Item No. **Report of the Head of Planning, Transportation and Regeneration**

Address 57-59 CORONATION ROAD HAYES

Development: Two storey side extensions and first floor rear extensions to both properties and conversion of existing 2 dwellings to 4 x 2-bed self-contained flats, involving alterations to rear elevation and demolition of existing single storey side elements

LBH Ref Nos: **75363/APP/2020/30**

Image showing Proposed Front Elevation with measurements highlighting proposed rooflines are 0.5m below main roof level and that width of extension is considerably less than the original house.

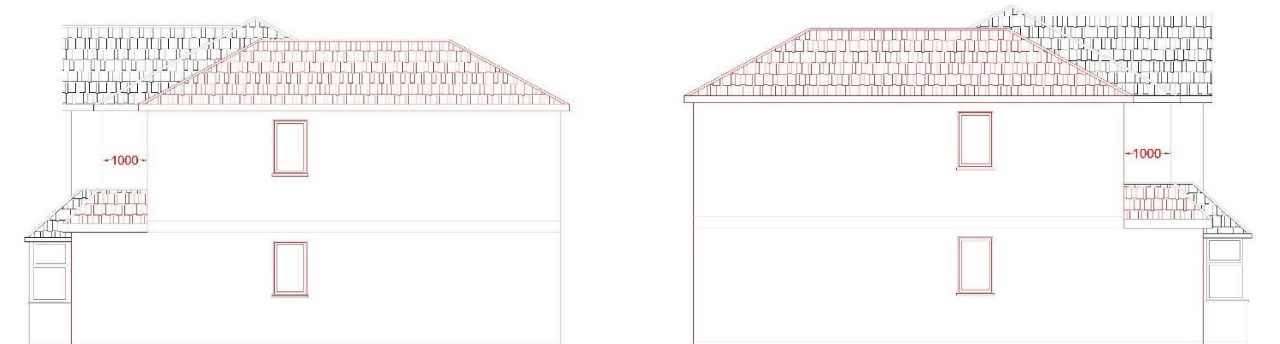
The proposed two storey side extensions, by virtue of their siting, size, scale and design, including the lack of a set back from the front at all levels, would fail to appear as a subordinate additions and would thus be detrimental to the appearance of the original dwellings and the visual amenities of the street scene and the character and appearance of the wider area. The proposal is therefore contrary to Policy BE1 of the Hillingdon Local Plan: Part One - Strategic Policies (November 2012) and Policies DMHB 11, DMHB 12 and DMHD 1 of the Hillingdon Local Plan: Part Two - Development Management Policies (January 2020).

It is considered that the two storey side extensions would appear subordinate to the main house. They would not be overly wide and would be appropriately set in from the site boundary however, given that the existing single storey elements are to be demolished, the side extensions should be set back 1m from the main front wall at both levels. The proposed extensions are not set back at ground floor level and, in fact, in combination with the porch, protrude forward of the main wall. Thus, the proposed two storey side extensions, by virtue of their siting, size, scale and design, including the lack of a set back from the front at all levels, would fail to appear as a subordinate additions and would thus be detrimental to the appearance of the original dwellings and the visual amenities of the street scene and the character and appearance of the wider area. The proposal is therefore contrary to Policy BE1 of the Hillingdon Local Plan: Part One - Strategic Policies (November 2012) and Policies DMHB 11, DMHB 12 and DMHD 1 of the Hillingdon Local Plan: Part Two - Development Management Policies (January 2020).

Image showing diagrams of rear extension and the 45-degree rules from Hillingdon council guidance.

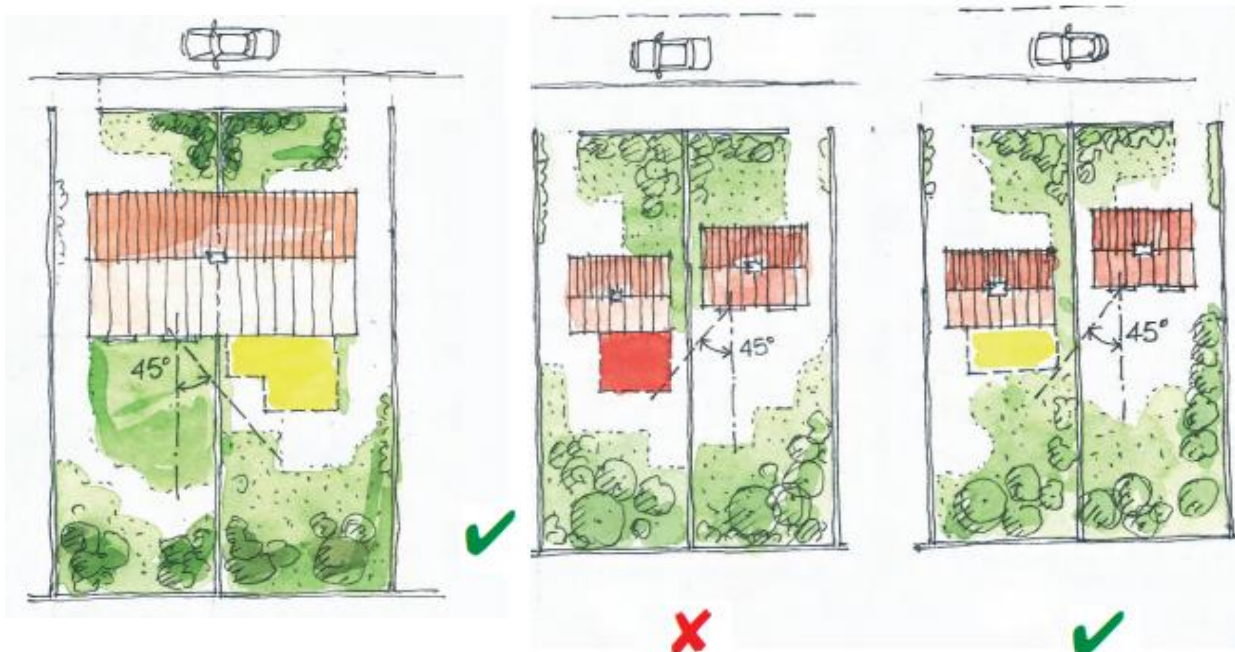
Furthermore, contrary to the Local Plan design guidance, the first floor rear extensions, in combination with the side extensions, would extend the full of both properties adding significant bulk and massing to the houses, which are originally modest in scale and would have very large crown roof elements, which would be totally out of character. Thus, the proposed extensions by reason of their cumulative size, scale, bulk, width, depth and design would result in an overly dominant and incongruous development that would fail to appear subordinate, would fail to harmonise with the architectural composition of the original dwellings and would be detrimental to the character, appearance and visual amenities of the street scene and the surrounding area. Therefore the proposals would be contrary to Policy BE1 of the Hillingdon Local Plan: Part One - Strategic Policies (November 2012) and Policies DMHB 11, DMHB 12 and DMHD 1 of the Hillingdon Local Plan: Part Two - Development Management Policies (January 2020).
